A. A. Takla Engineering, PLLC

Project: 146 Emma McLeod lane
Location: Dunn, NC
Company: STE General Contractors
Care Of: Shane McLeod
Subject: Pier Footing Extension
Job Number: 1076-23

**201 FOUNDATION PLAN**  
SCALE ----- 1/4" = 1'-0"

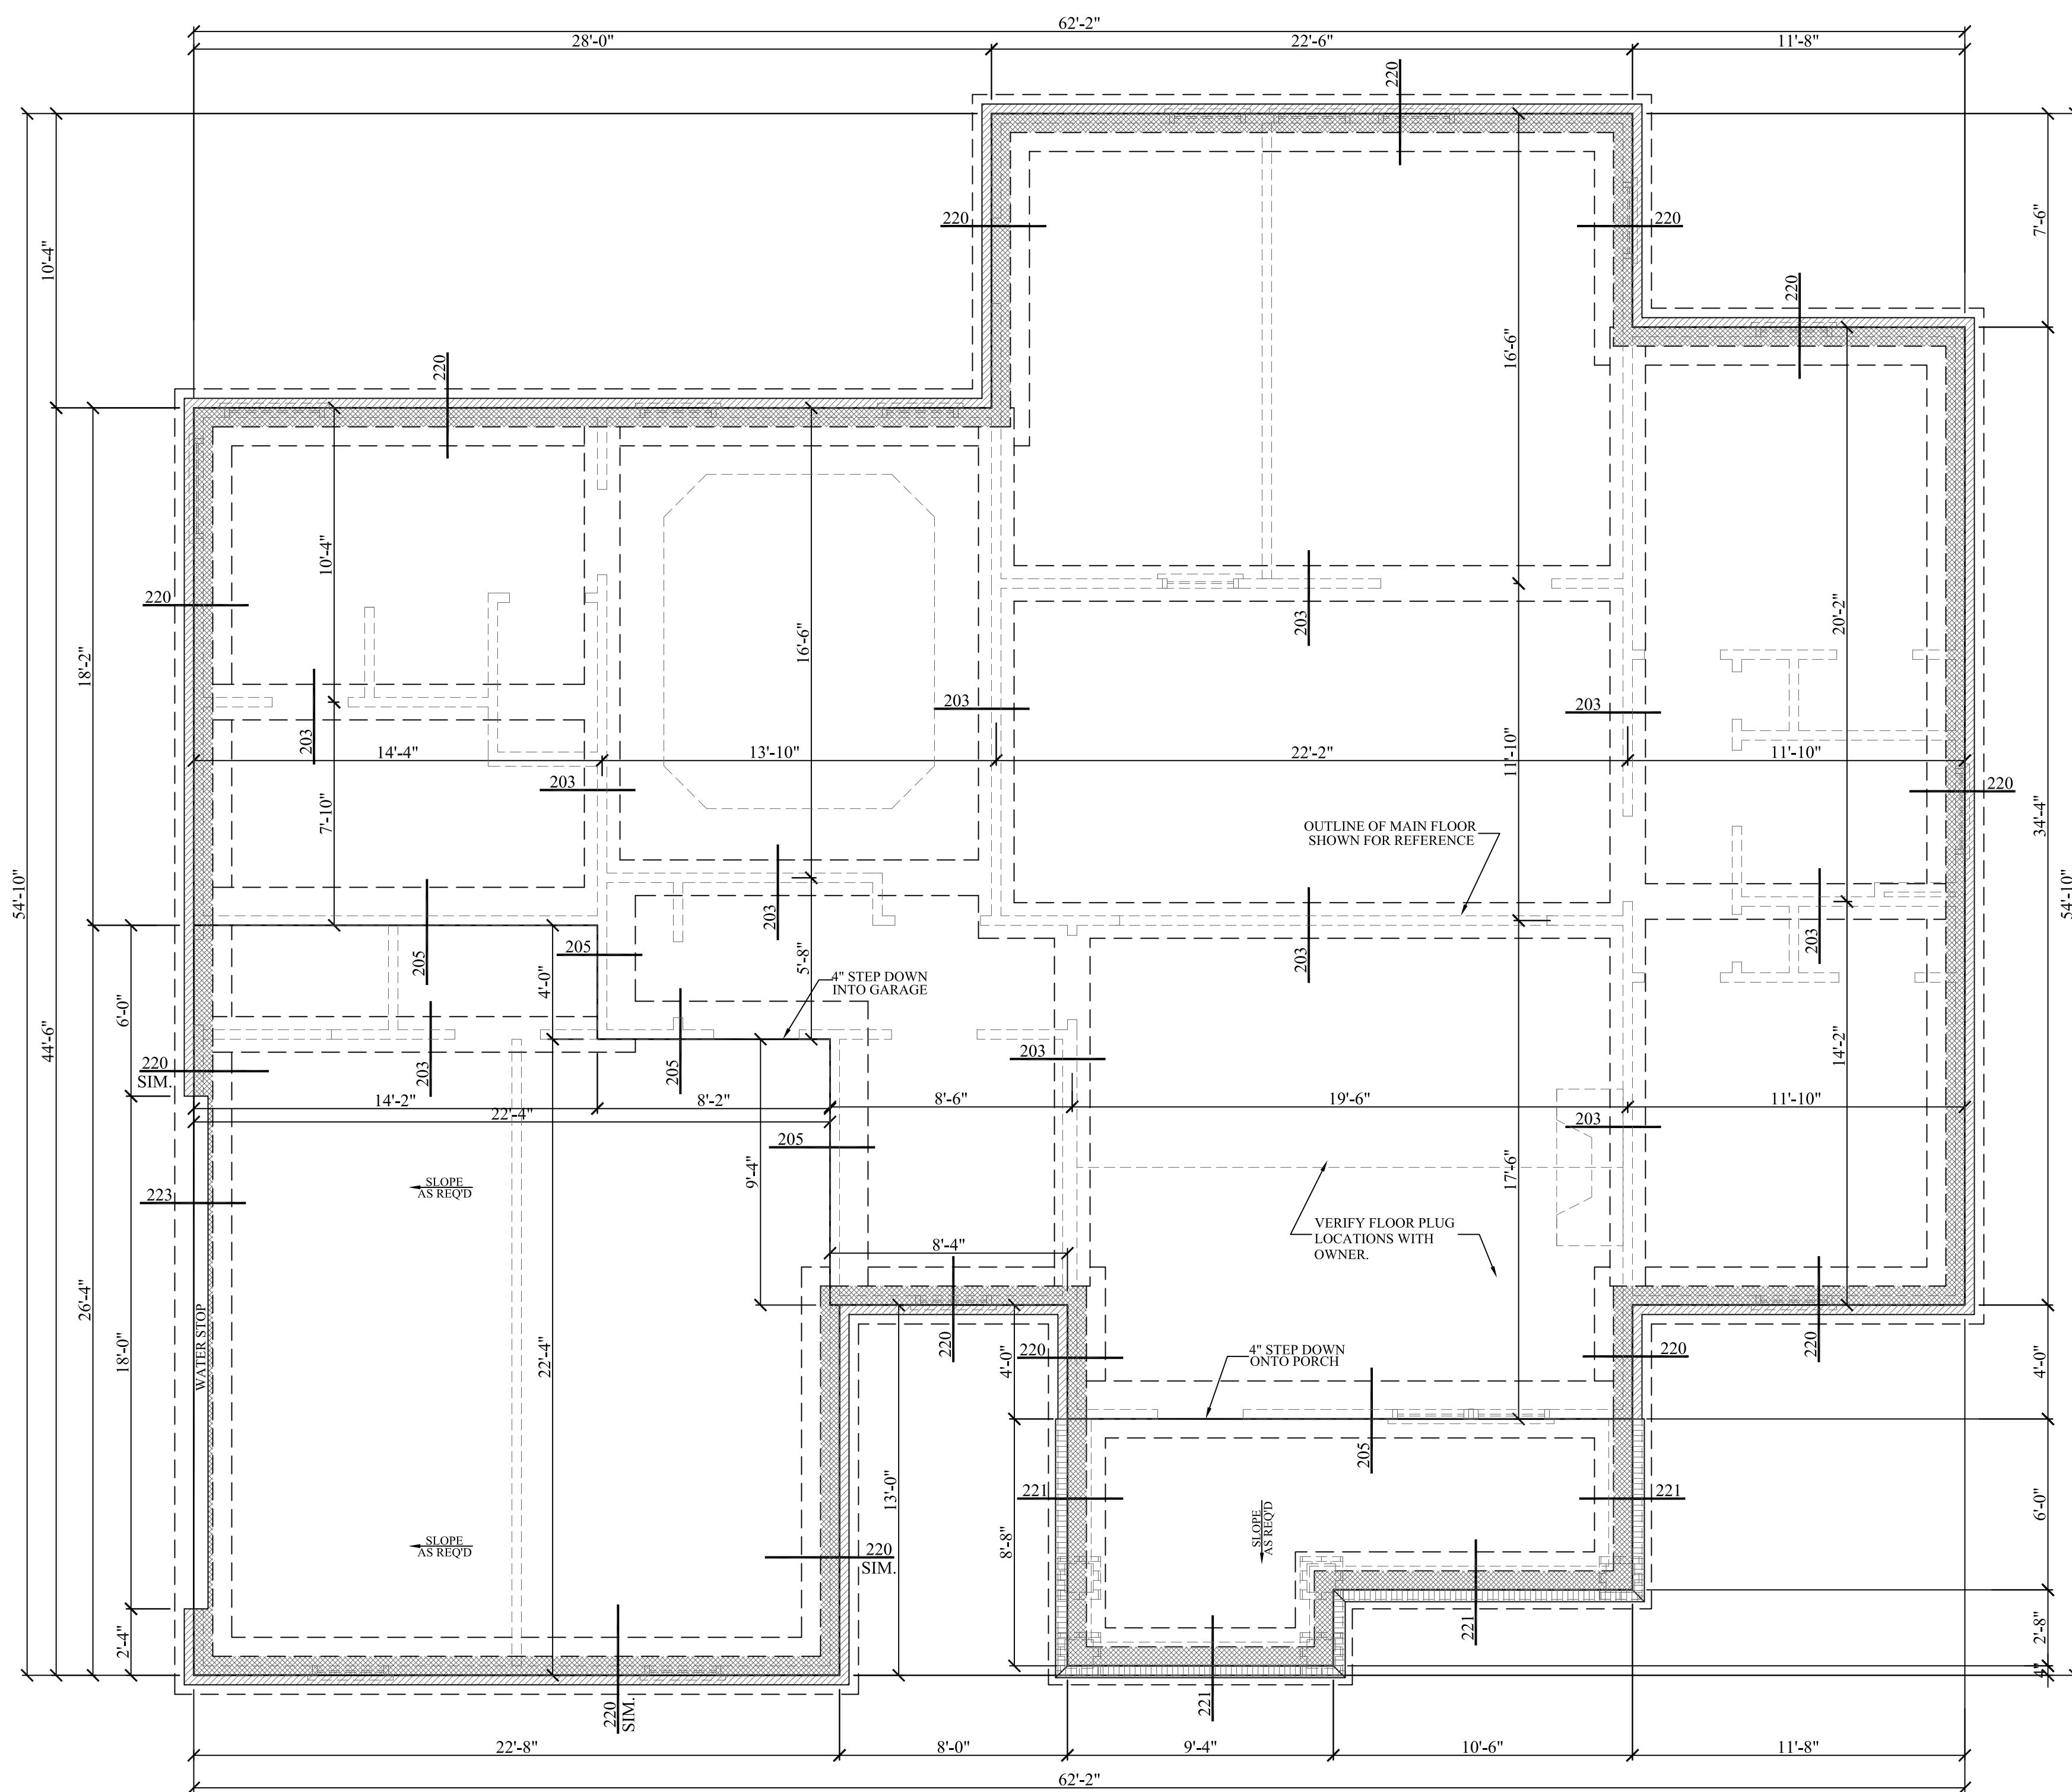
As requested, Andy Takla, PE prepared this report on July 12th, 2023 to provide the builder with a repairing the pier footing projection of the front-right most pier of the front porch.

Based on review, we recommend implementing the detail shown below to any sides lacking at least 2" of projection.
